Subject: RE: Y/101/19/DOC - Yapton View (land off Burndell Road), Yapton, BN18 0HW

Site Photographs

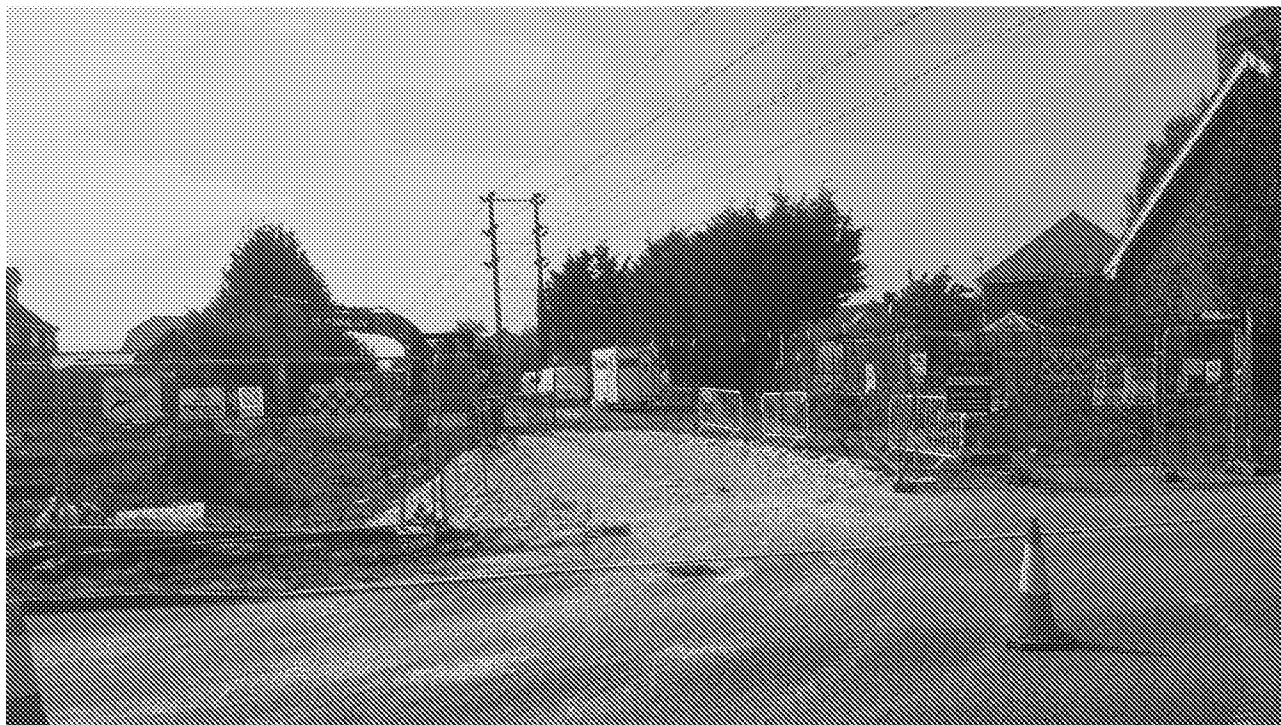
The three pictures in Appendix A do not appear to show the membrane or evidence imported material; please may photographs demonstrating the membrane installation at depth and copies of the transfer tickets for the imported material be provided.

I have also attached the Completion Report which shows the membrane installation on page 15 and evidence of imported material on page 19.

2.3 Root barrier installation works

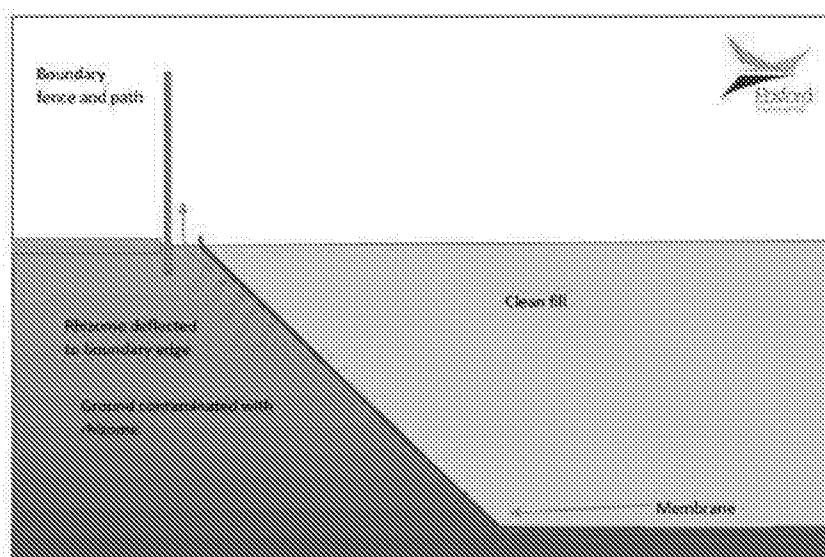
Thank you for the additional documents; the majority seem satisfactory but please may the applicant confirm whether the root membrane also acts as the visible deter-to-dig membrane (as per Geo-Environmental's RSVP) across this area of the site?

Ebsford have confirmed that the root barrier is installed vertically along the boundary of the site as per the pictures within the completion report supplied and will be a visible deterrent to excavation.
